Application Ref:	3/2025/0575			 Ribble Valley Borough Council <small>www.ribblevalley.gov.uk</small>				
Date Inspected:	04/09/25	Site Notice:	04/09/25					
Officer:	LW							
DELEGATED ITEM FILE REPORT:					APPROVAL

Development Description:	Proposed single storey rear extension forming a sunroom.
Site Address/Location:	3 Audley Clough, Clitheroe, BB7 1FX.

Client		
Mr and Mrs Clarkson		
Job Title		
Proposed Rear Extension at: 3 Audley Clough Clitheroe Lancashire BB7 1FX		
Drawing Title		
Proposed Plans, Elevations and Section.		
Scale	Date	Drawn
Various @A1	June '25	TDM

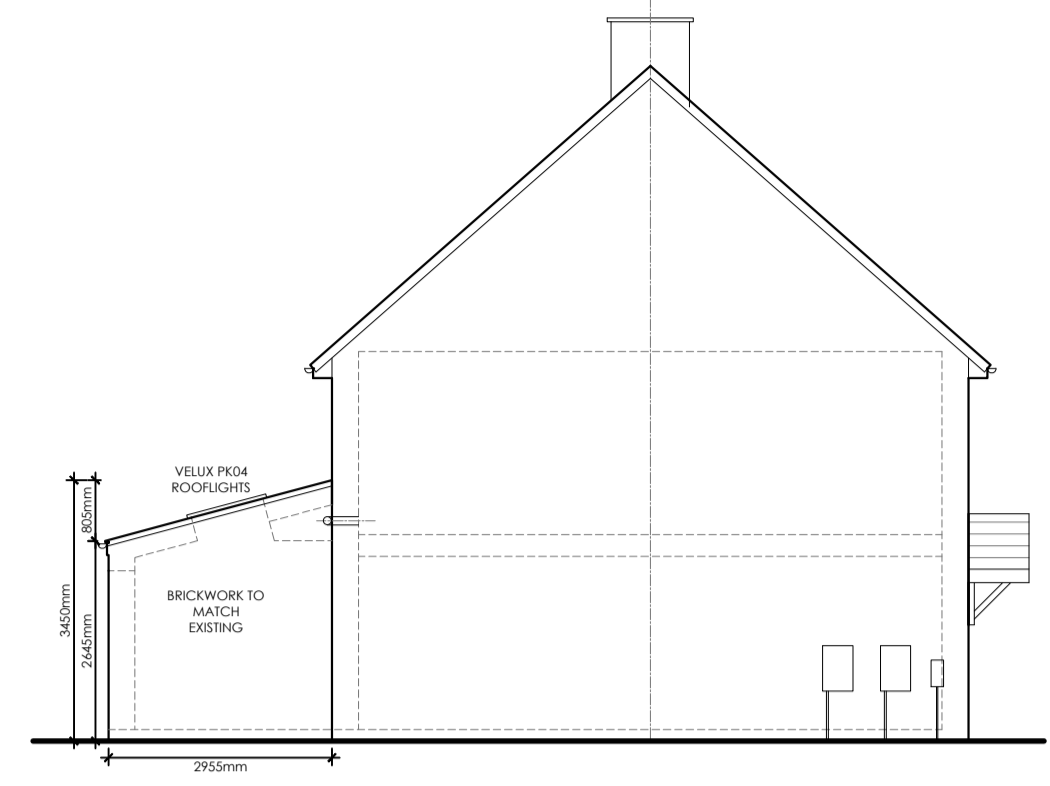
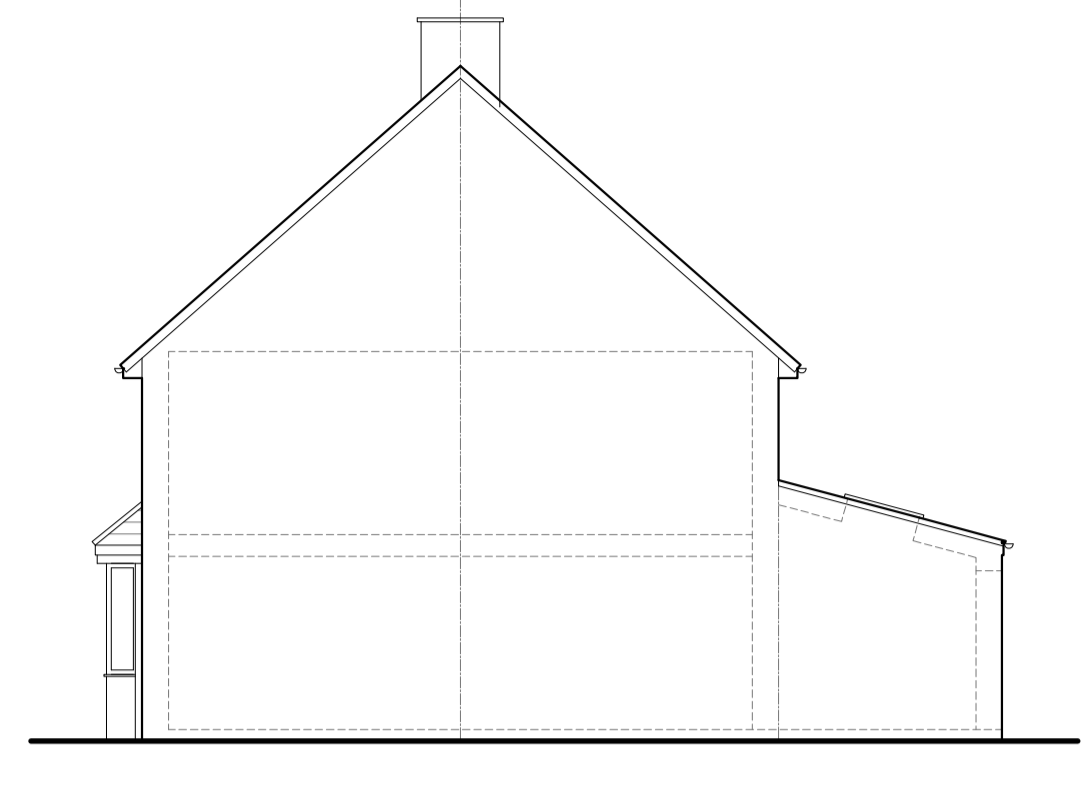
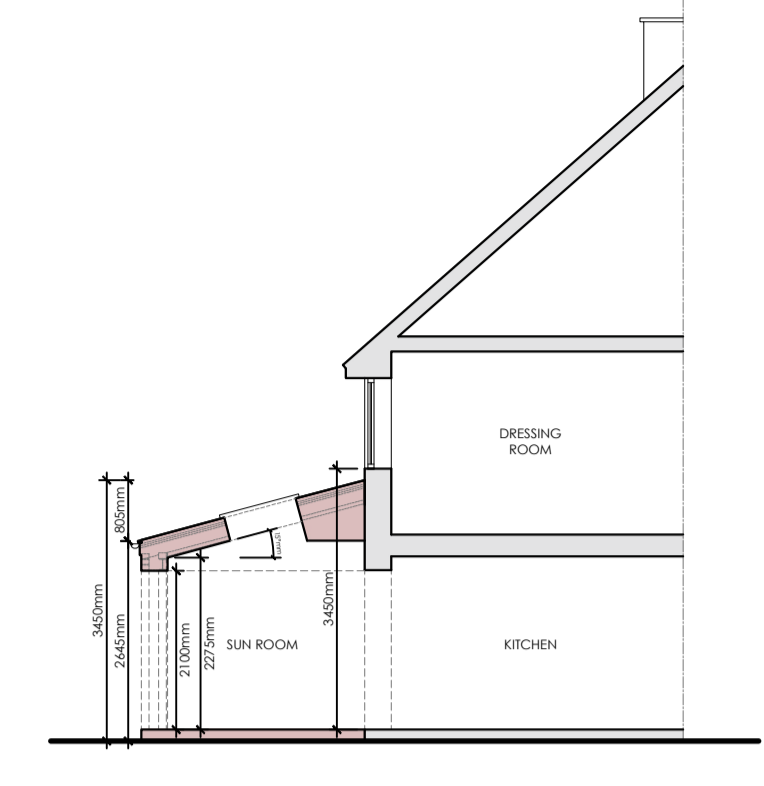
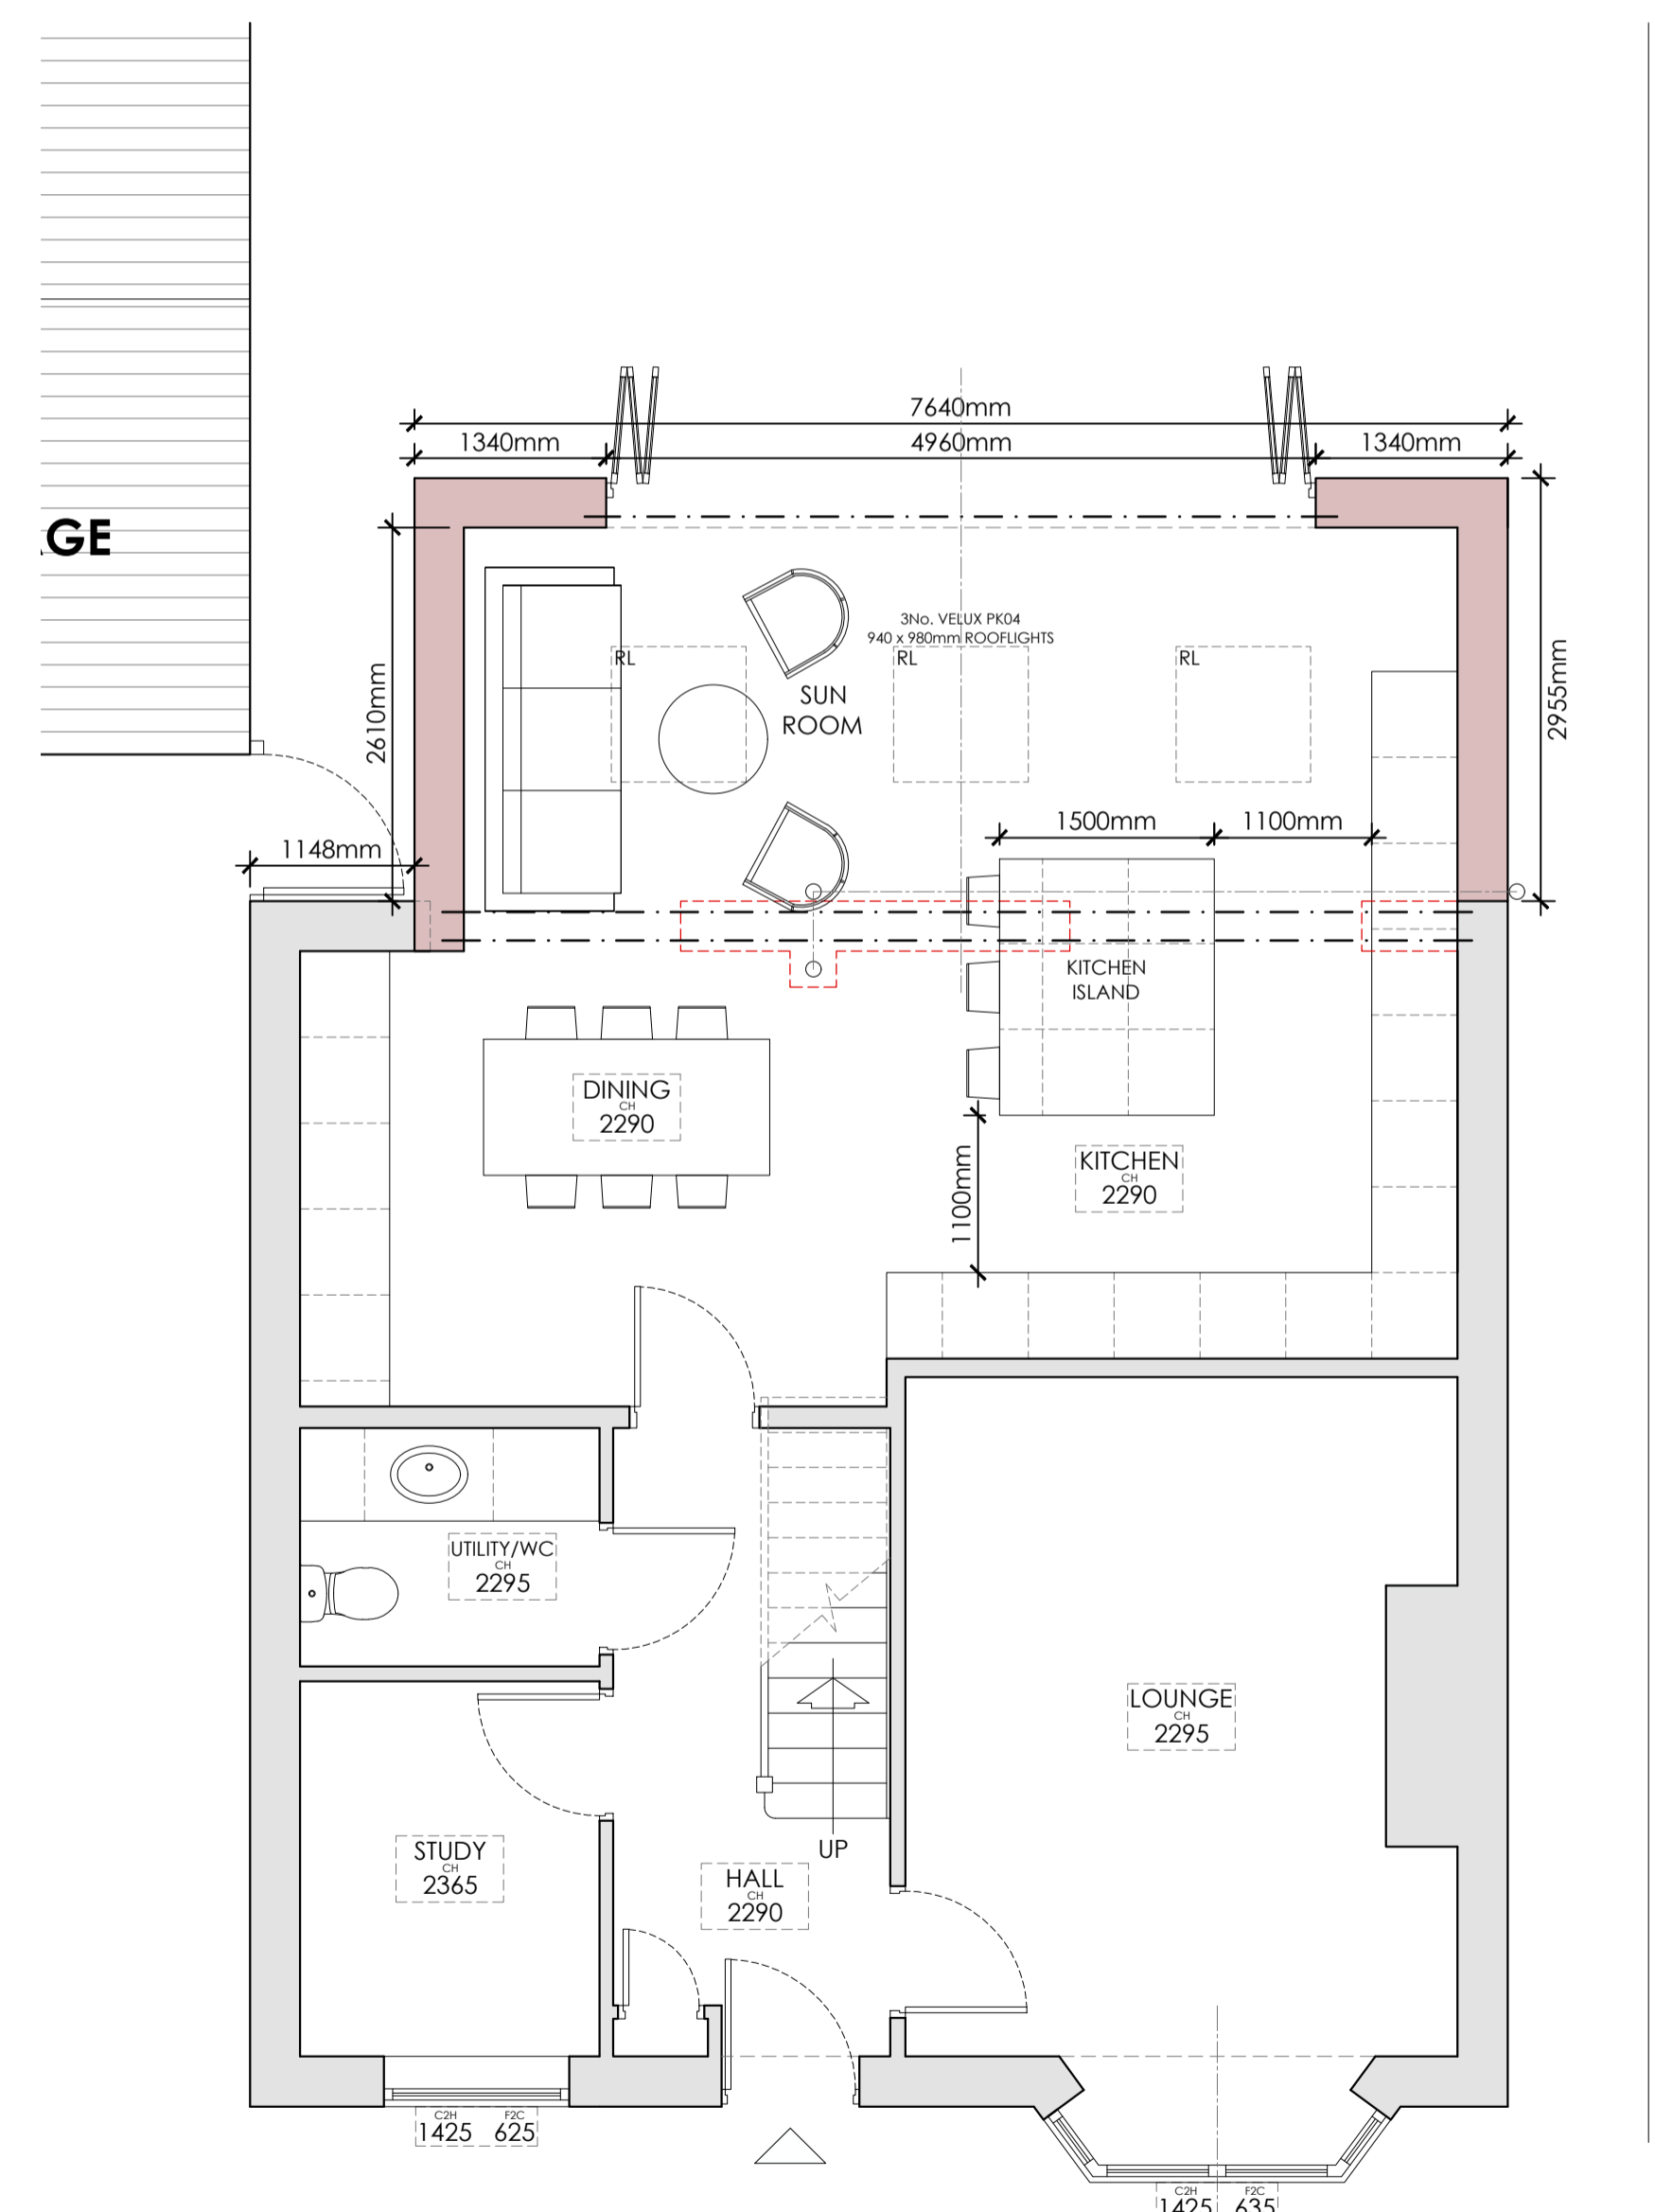
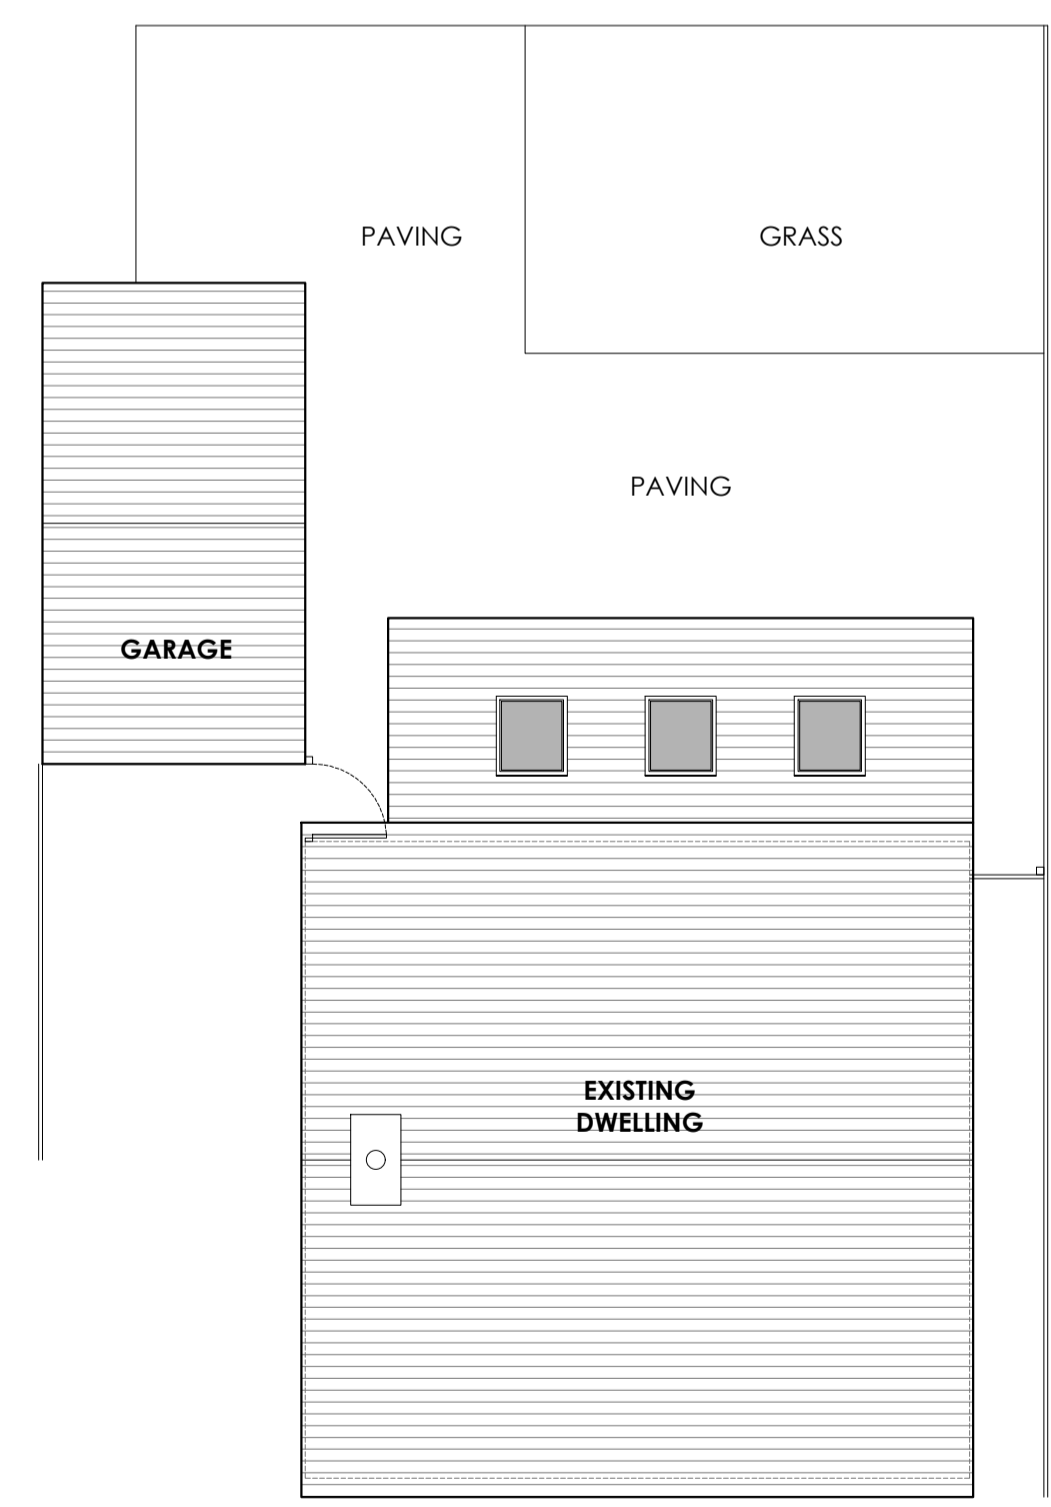
Consent is sought for the construction of a single storey rear extension with an outward projection of 3m and width of 7.6m. The proposed development would incorporate a lean-to roof form measuring 2.6m to the eaves and 3.5m to the ridge and would feature a set of bi-folding doors to the rear elevation and 3no. roof lights.

The openings proposed to the extension would provide views primarily towards the rear garden area associated with the application property and therefore no new opportunities for direct overlooking or loss of privacy are anticipated in this respect. Furthermore, the proposal would have a relatively modest 3m rearward projection and as such, would not result in any significant loss of light or overbearing impact upon the neighbouring residents at No.5 Audley Clough. The development would also remain approximately 14m from the residential properties along Pendleton Avenue to the south-east, adequately screened by the application property's detached garage, as well as 18m from the dwellings located to the south-west.

The proposed extension would be sited to the rear of the application property and therefore would not be afforded a high level of visibility from the adjacent public realm. Notwithstanding this, the proposal would comprise a relatively modest addition to the application property that would appear appropriate in size and scale when read in context with the existing built form. Furthermore, the proposal would be finished in materials to match the external appearance of the primary dwellinghouse, ensuring visual integration and further reducing the impact of development.
